REQUEST

The petition proposes a unified development plan with common uniform zoning and development regulations for the development of a residential multi-family community on the entire 48.21 acre site which includes both the 36.67 acre Charlotte portion and the 11.54 acre Concord portion. The petition proposes up to 700 multi-family dwelling units.

Childress Klein Properties

SHEET NUMBER  
**RZ-1**

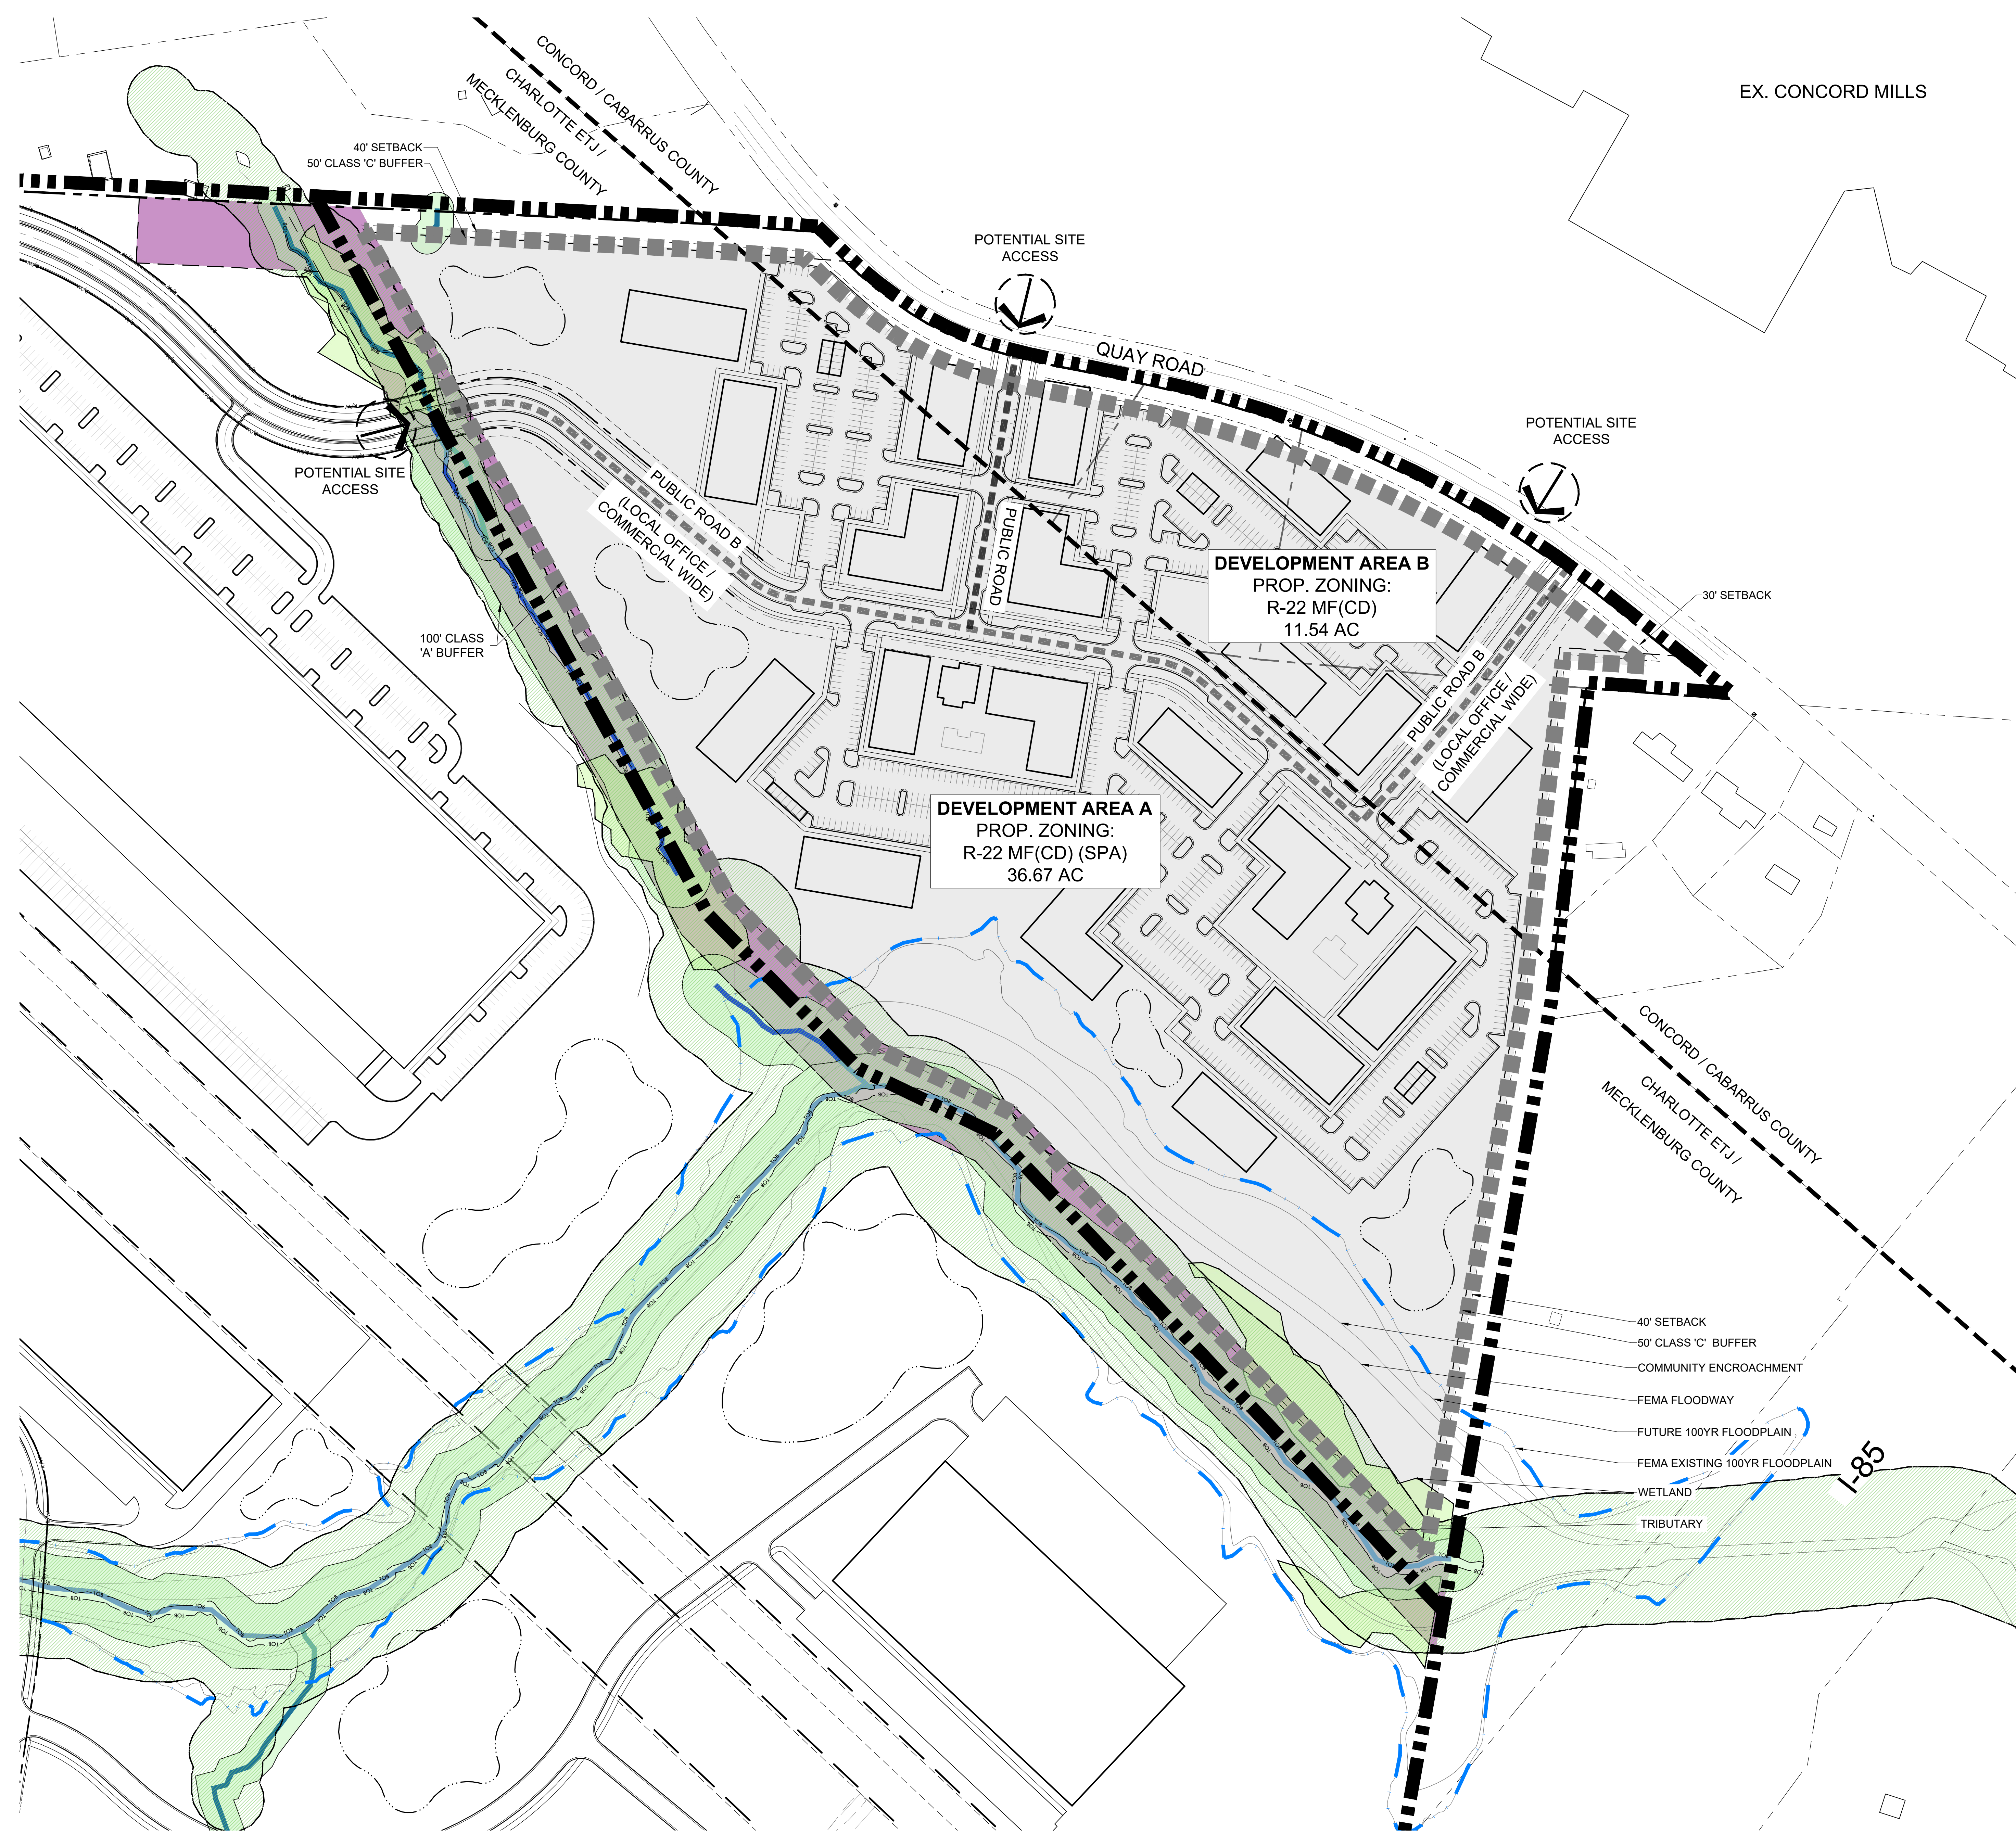
1. Label and call out 8-foot planting strip and 8-foot sidewalk on roads on site plan.
2. Based on latest conversation with Land Development Subdivision, please label Road B as publicly maintained within Mecklenburg county on site plan and alter conditional notes in sections 3, 4, and 5 to reflect changes.

3. Minimum open space for R-22MF is 40%. Update plan.
4. In section 1e. the number of principle buildings (24 or 27) don't match.
5. Setbacks will apply to all internal required streets.
6. Make Road B public.
